Suffolk County Council (20041323)

Comments on Responses to the Examining Authority's Further Written Questions (ExQ2)

Bramford to Twinstead (EN020002)

9 February 2024

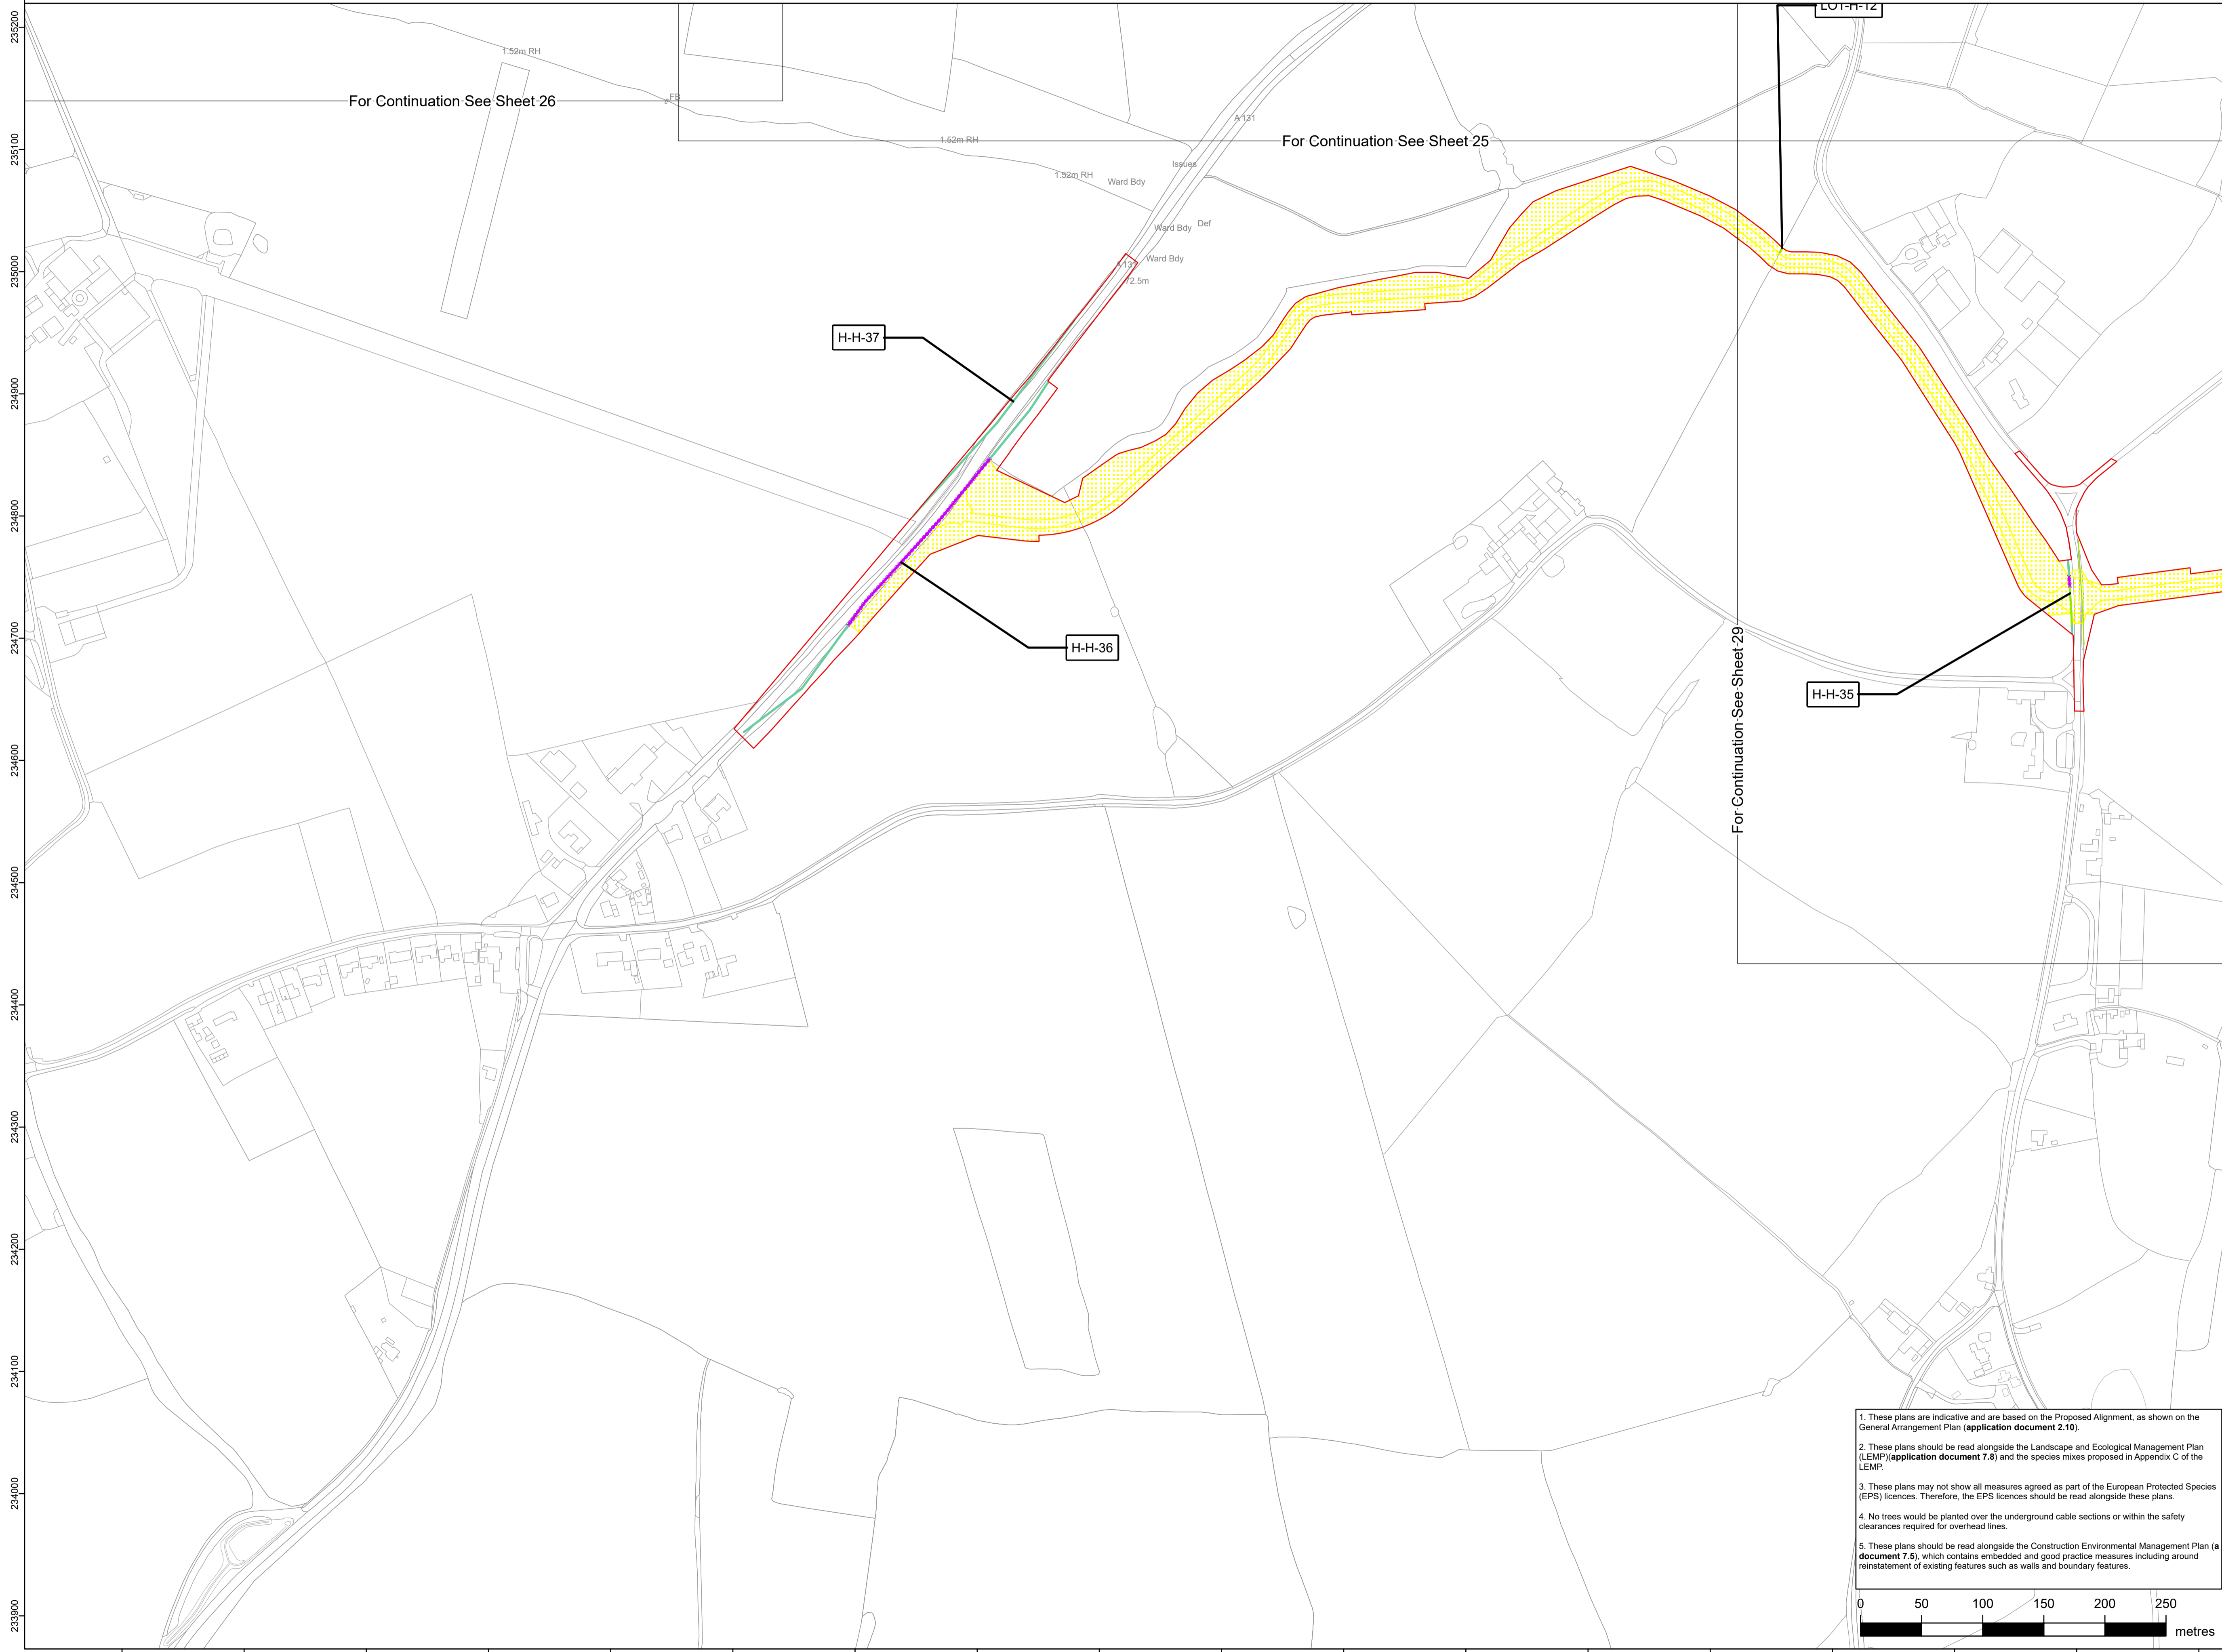
proposed within the Environmental Gain Report [APP-176] .	
1d	Visual Assessment	LV2.9.4		<p>SCC (Landscape) welcomes the additional hedge planting included by the Applicant on the south-western boundary of the Stour Valley West CSE compound, shown on The Vegetation Reinstatement Plan [Sheet 28, [REP7-009]], which will help to soften and filter the views to the compound, especially as the compound would be slightly sunken in comparison to the surrounding contours.</p> <p>SCC (Landscape) would support further planting to the south-east of Mabb’s Corner, regardless, whether it would be for mitigation or biodiversity net gain.</p>
1e		Lv2.9.6	<p>The LEMP Appendices including Appendix A: Vegetation Retention and Removal Plan (documents 7.8.1 (B)) and Appendix B: Vegetation Reinstatement Plan (document 7.8.2 (C)) are based on the Proposed Alignment shown on the General Arrangement Plans [APP-018]. This is based on the current designs. However, the detailed design would be undertaken by the Main Works Contractor, when appointed, and therefore could change within the flexibility provided by the Limits of Deviation. The vegetation to be removed and therefore reinstated, could change from that assumed in the</p>	<p>When read together, the first and last paragraph of the Applicant’s response (see on the left) seem to state that while there may be necessary changes to vegetation removal and reinstatement as the detailed designs emerge, it can already be said with some certainty that these changes would not result in new or different significant effects.</p> <p>While SCC (Landscape) is concerned that the changes within the LoD during the detailed design stage may result in additional vegetation losses in some areas, the Council would seek reassurance form the Applicant that the changes during the design stages and within the limits of the LoD would actively seek to reduce vegetation losses, wherever possible. Given that the</p>
